EPC PPR-19-054 (RMG Job No. 170915)

April 21, 2020

Re: Frontier Sptorsman - First Submittal
PPR-19-054
3385 Pheasant Lane
Peyton, CO 80831

This letter serves as a detailed letter accompanying the revisions to the Development Plan first submittal set for Frontier Sportsman's Club at the address 3385 Pheasant Lane in the town of Peyton, county of El Paso, state of Colorado. The County review comments are listed as presented in the Memorandum for the First Submittal dated February 11, 2020. Owner/develop and/or design team responses to said comments are provided below each item. Responses following "MT2" represent comment responses from the general contractor MT2, LLC., responses following "RMG" represent comment responses from the design engineer RMG-Rocky Mountain Group (Richard Lyon, PE). All resubmittal documents and supplemental information requested per the County review comment letter are acknowledged.

LAST SAVED: 4/2/2019 12:20:02 PM PATH: T:\Projects\Site_Special\2019\170915\Sub-Basin\Drawings\From BIM\OS\Sheet\Prop_Conditions_Sub-Basin.dwg

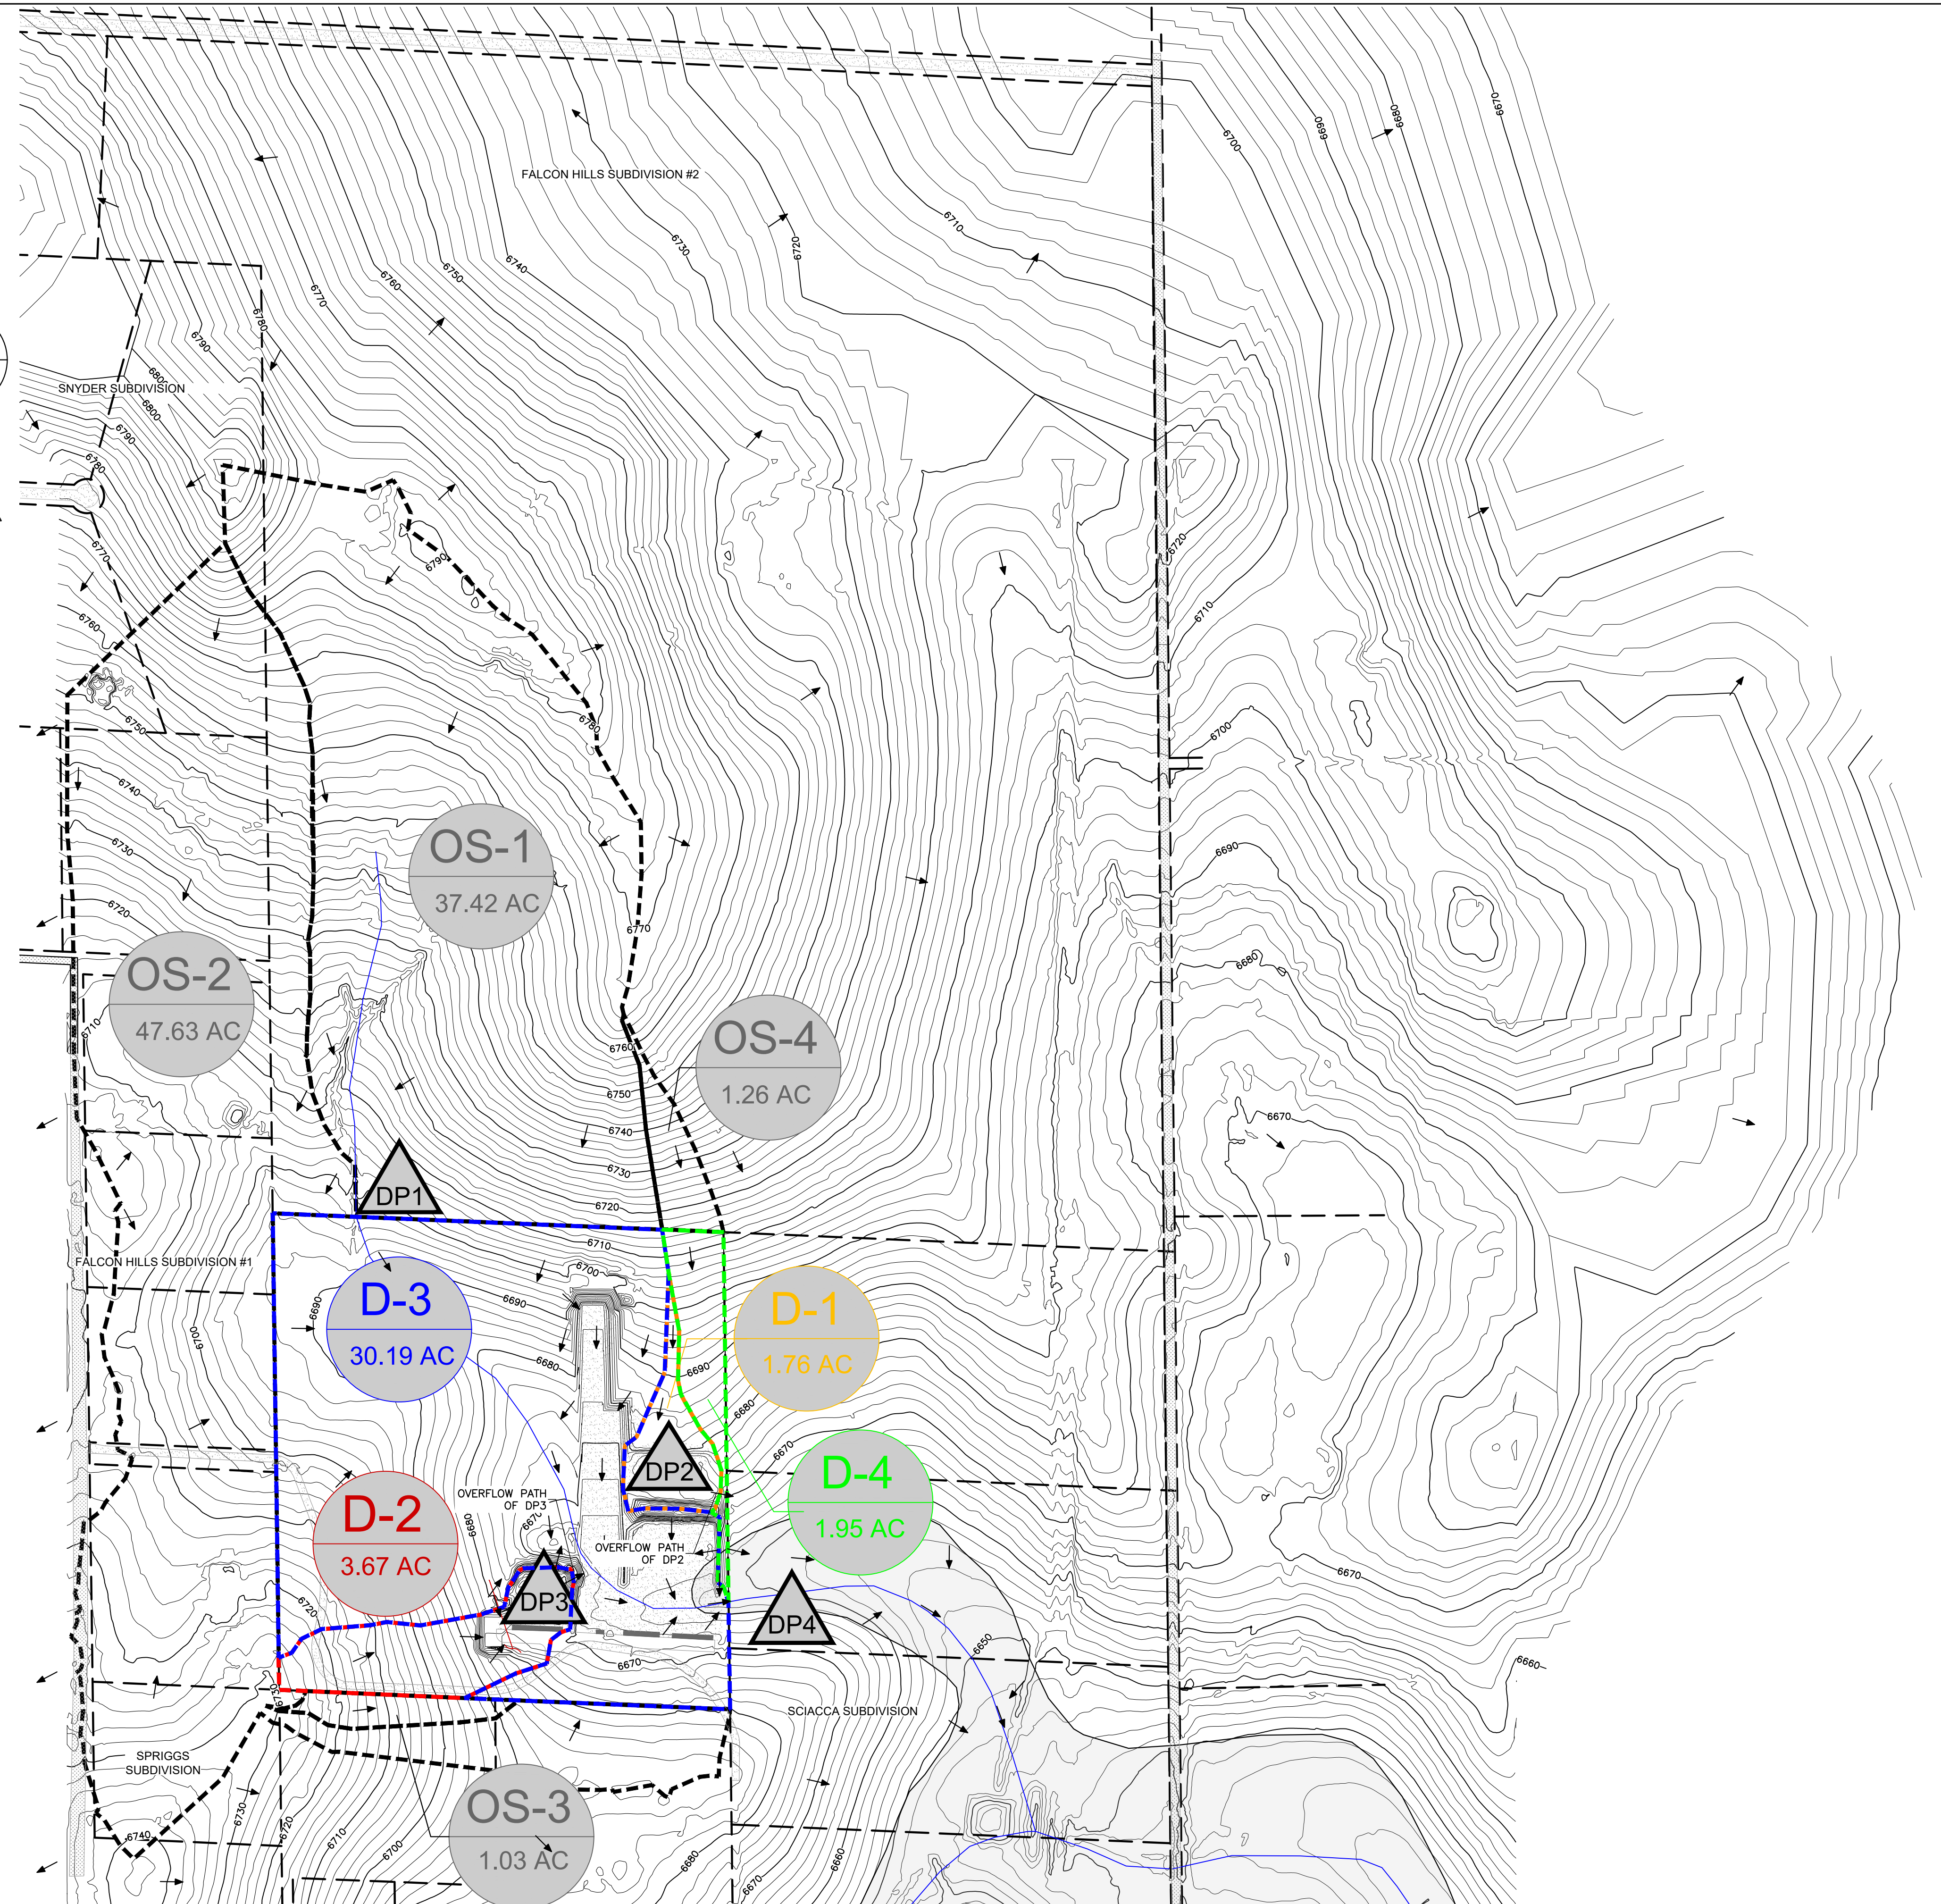
3. Indicate the Drainage Basin and the study associated with this area and address any need for detention if necessary.

RMG: No detention or WQCV is required as there is no proposed impervious area. Language to the effect of "land disturbance to undeveloped land that will remain undeveloped per section I.7.1.B.7 of the El Paso County ECM" is used throughout the report.
